Submission by Fen Ditton Parish Council ref ISH5

For 12 April 2024

This is FDPC’s submission at D7 with references to ISH5 – Traffic and Transport Agenda (EV-009a) and Action Points (EC-009b)

Submission by Fen Ditton Parish Council

Drawing Number
 Figure 8.16 (Sheet 1)

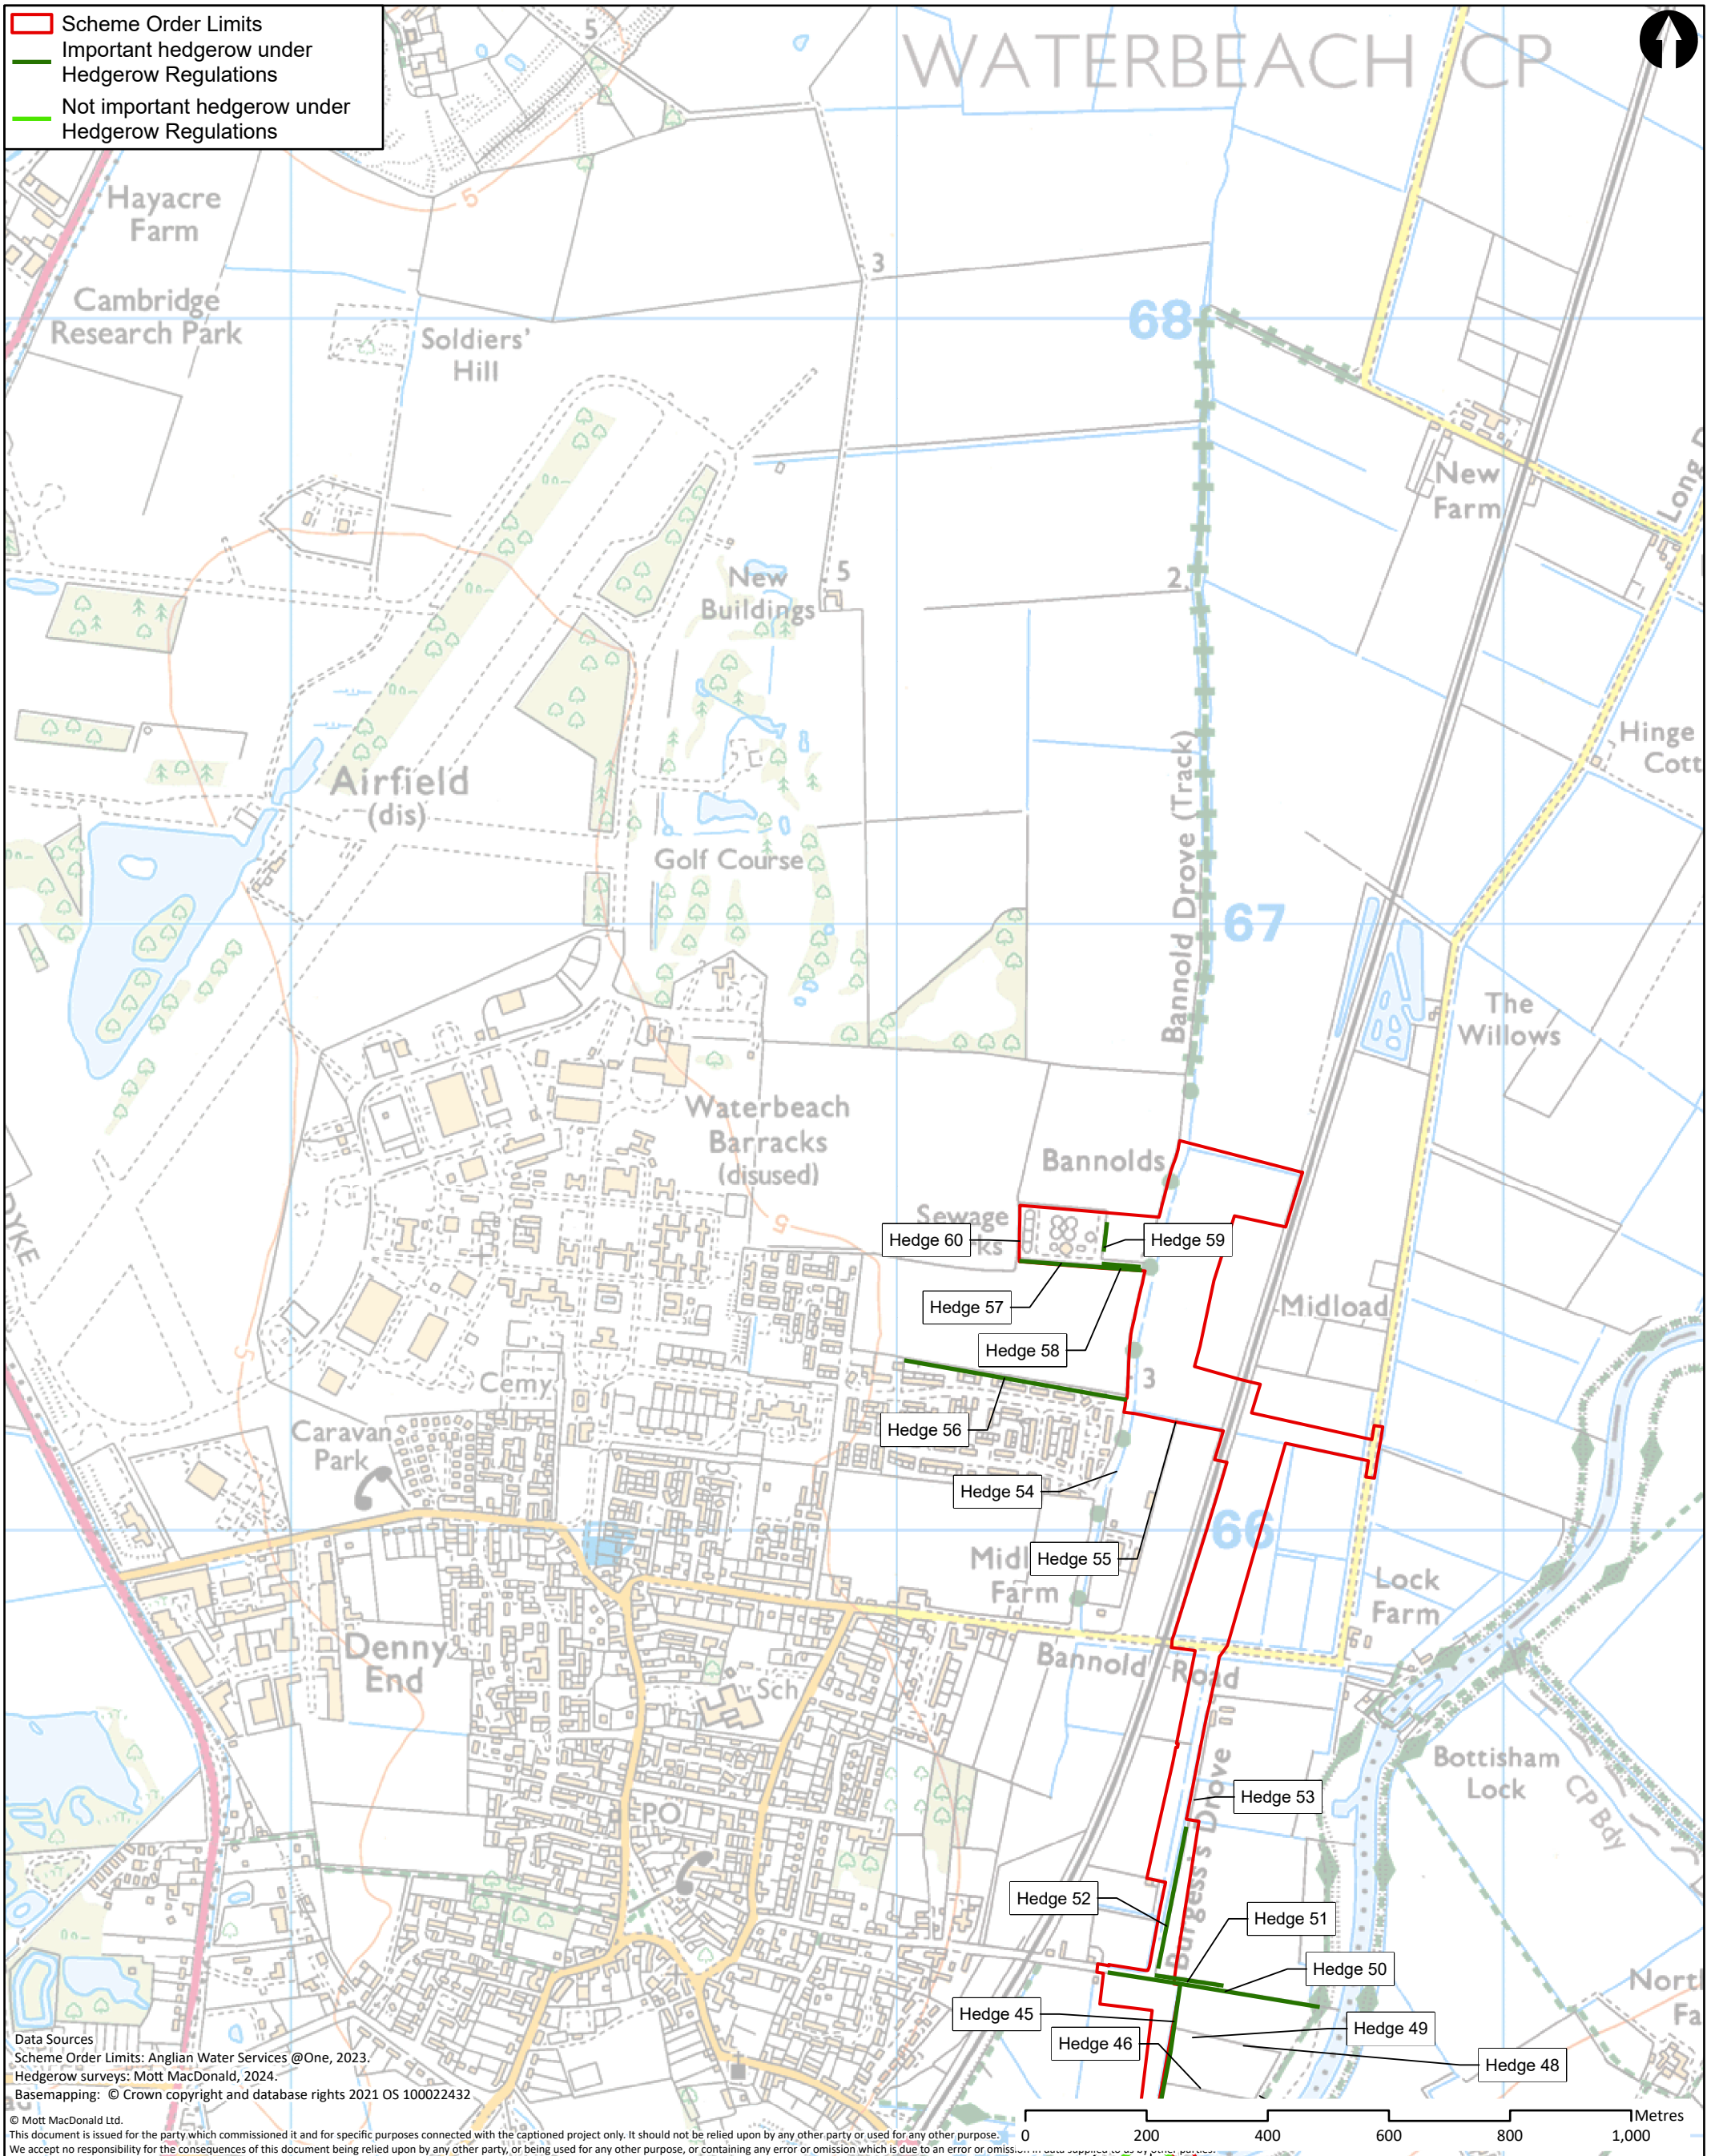
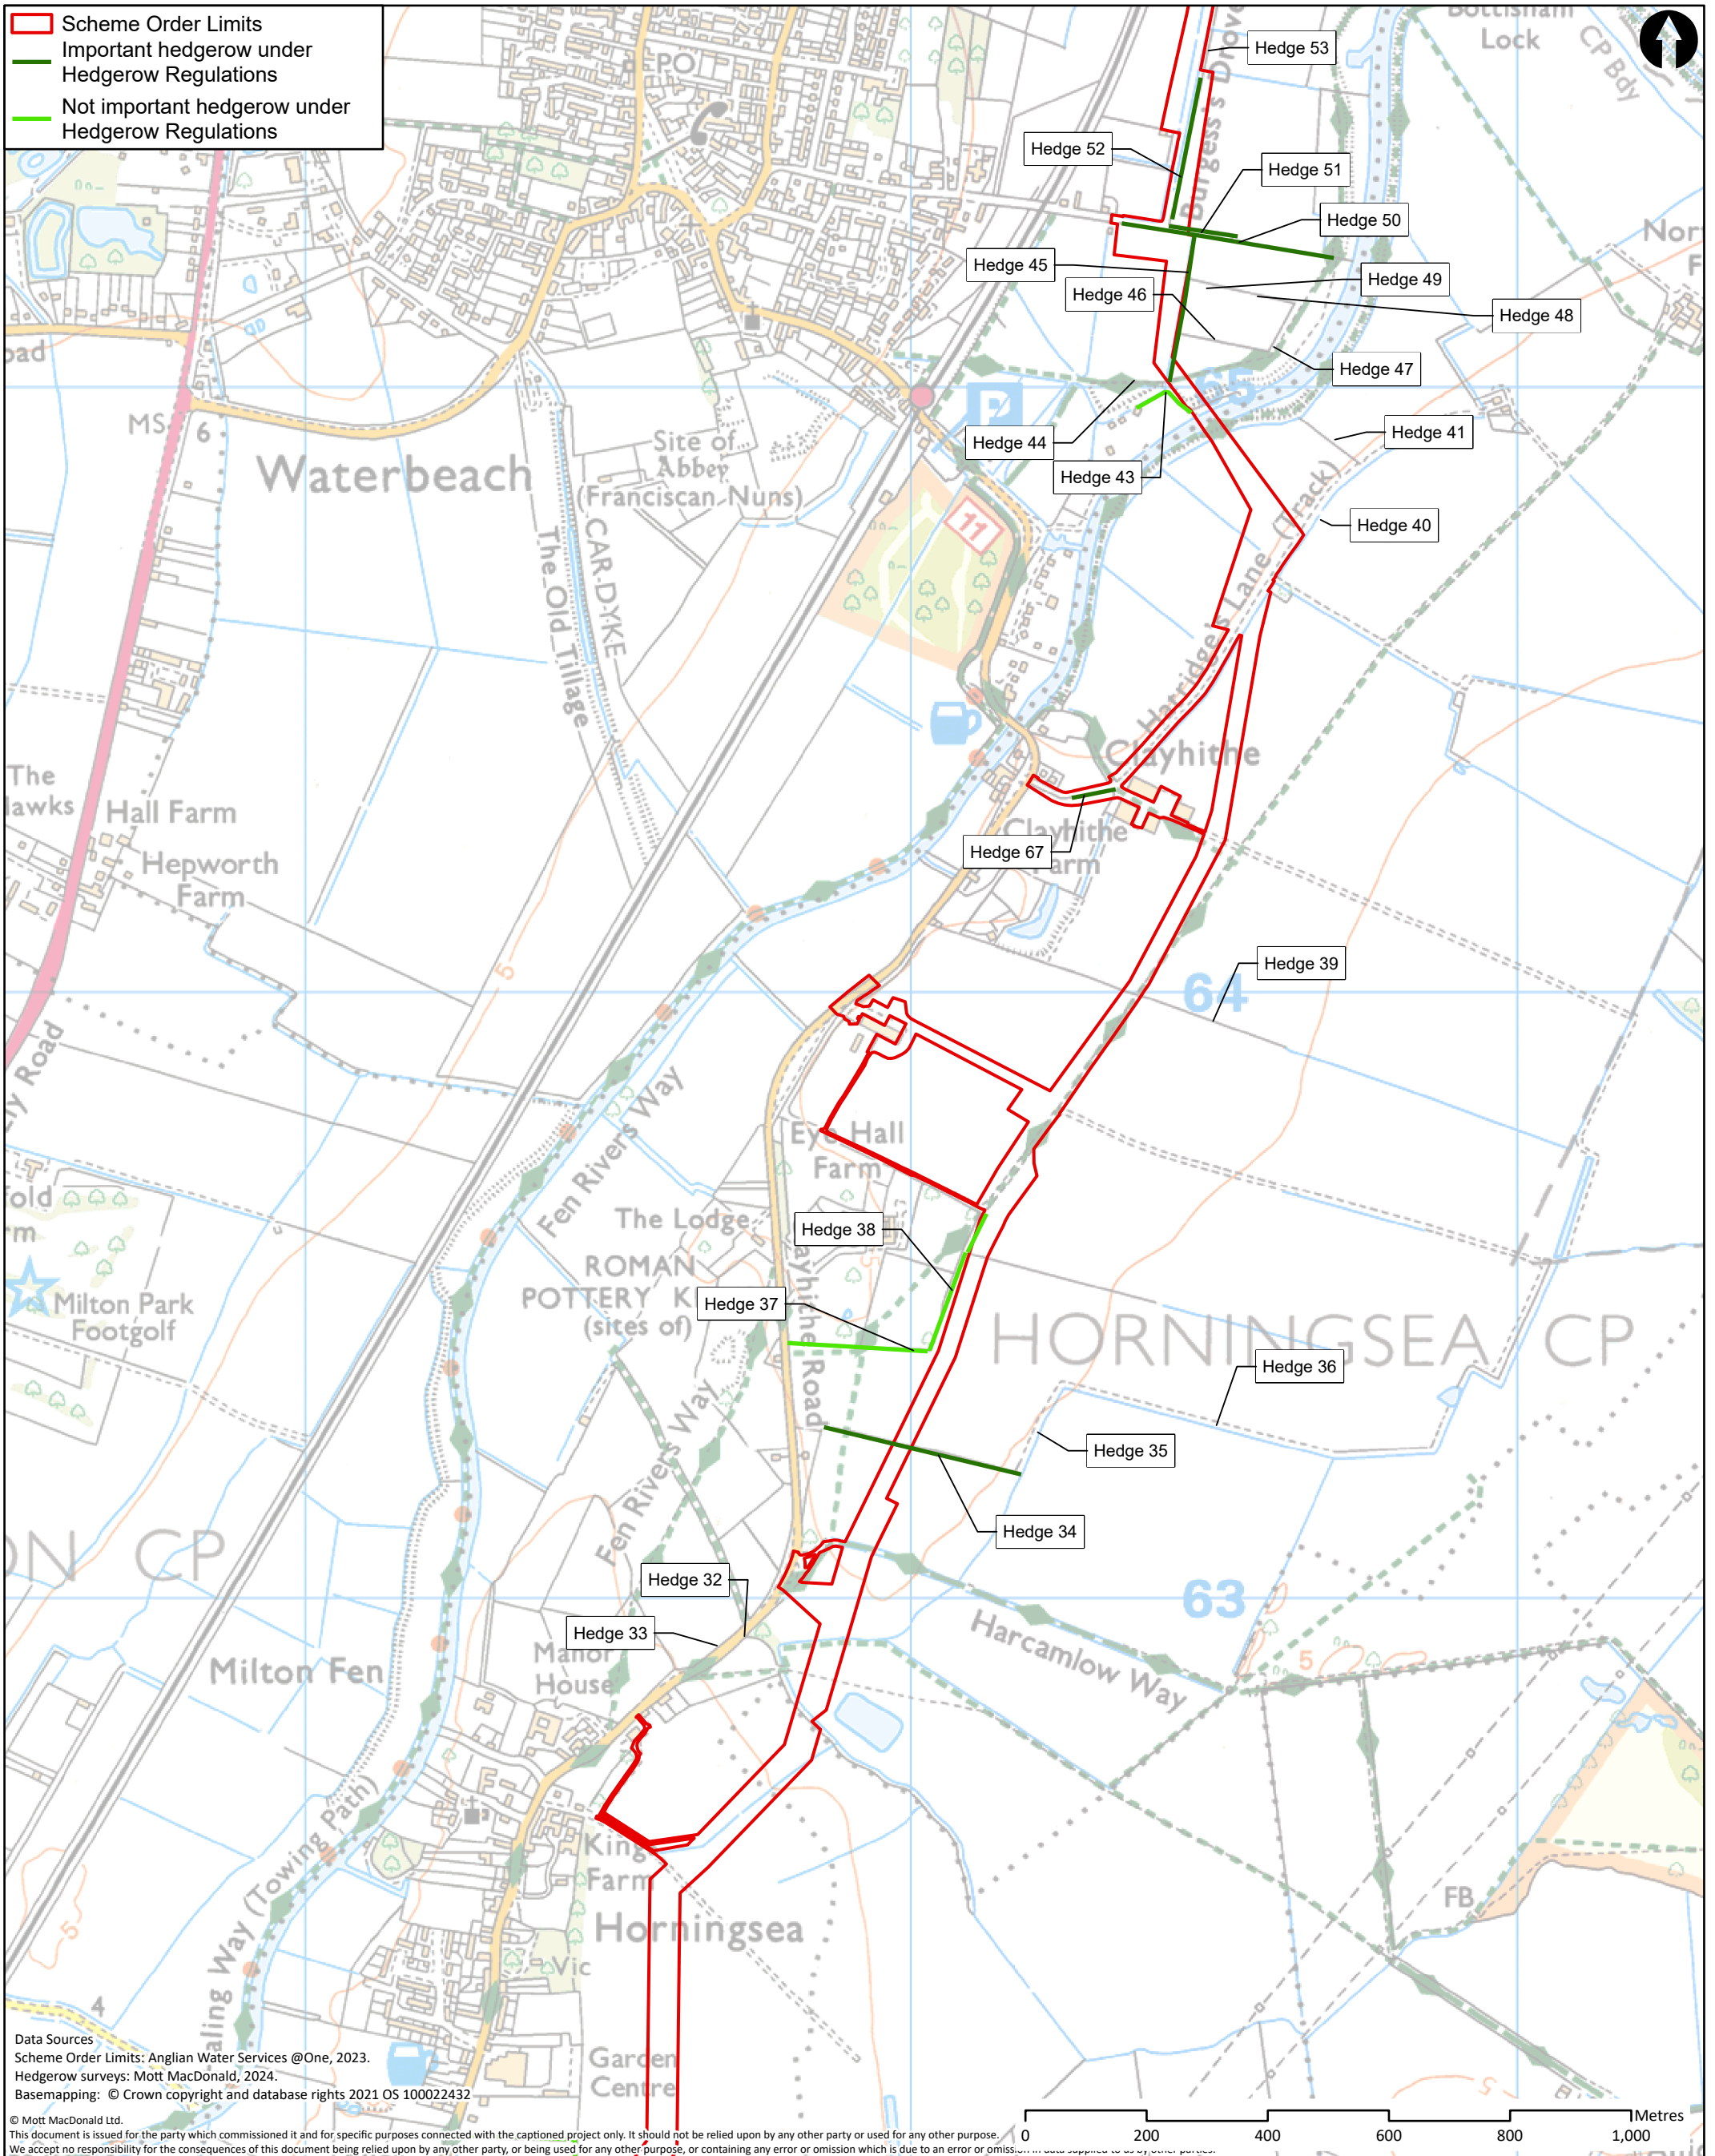
<p>Agenda Item 2 f) – Policy 23</p>	<p>FDPC noted that ‘arrangements.. and/or signage’ are covered in the County Local Plan Policy 23 para 3.2.3. FDPC requested that in addition to the proposed geofencing, signage banning HGV access to the WWTW is placed at the entrance to High Ditch Road at the Newmarket Rd junction during construction and operation. In operation, signage banning entry by HGV exiting the WWTW should be placed on Horningsea Rd at the junction with the A14 on slip at the lights. This request links to para 4.3.20 of ES Chapter 19 Traffic and Transport. FDPC welcomes Action point 11.</p>	<p>Chapter 19 Traffic and Transport (REP6-037) EV-009b</p>
<p>Agenda Item 4-AOB Hedgerows</p>	<p>FDPC have inspected the revised DCO Hedgerow Plans (REP6-005) and welcomed the corrections made but noted there are still hedgerows in the Parish within the areas where land will be acquired or used (ie the Scheme Order Limits) that are not shown correctly. FDPC accepts confirmation from the Applicant that hedgerows wholly outside the Limits had been removed</p>	<p>Hedgerow Plans (REP6-005)</p>

<p>from the Plans and that hedgerows crossing from inside to outside were still shown in their entirety.</p> <p>FDPC queried if areas of hedgerow and vegetation that could be retained could be protected through a mechanism under the LERMP.</p> <p>Post Hearing Note: Examples of possibly incorrect Hedgerow Plans are the inconsistency on Hedgerow Plans Sheet 3 where the hedgerow on the north side of Filly Lane is omitted whereas the Book of Figures – Biodiversity Sheet 8.6 (REP6-046) shows the same hedgerow with a small extent inside the Limits. Another example occurs where the vegetation running along the east side of Horningsea Road will be removed between points H5 and H6 but there appears to be 20m or more length with a 5m maximum width (these dimensional criteria are referred to in para 1.4.8 in Appendix 8.2: Hedgerow Baseline Technical Appendix) north of point H6 that has been classed as scrub rather than as a length of hedgerow bounded by scrub to its north.</p> <p>In view of the lack of time now available to check or ground truth the Plans, FDPC query if the Ecological Clerk of Works or others can be tasked with supervising the setting out of fence lines and reptile barriers to avoid unnecessary damage to existing hedgerows, trees or scrub vegetation.</p>	<p>Book of Figures – Biodiversity Sheet 8.6 (REP6-046)</p> <p>Appendix 8.2: Hedgerow Baseline Technical Appendix (REP6-063)</p>
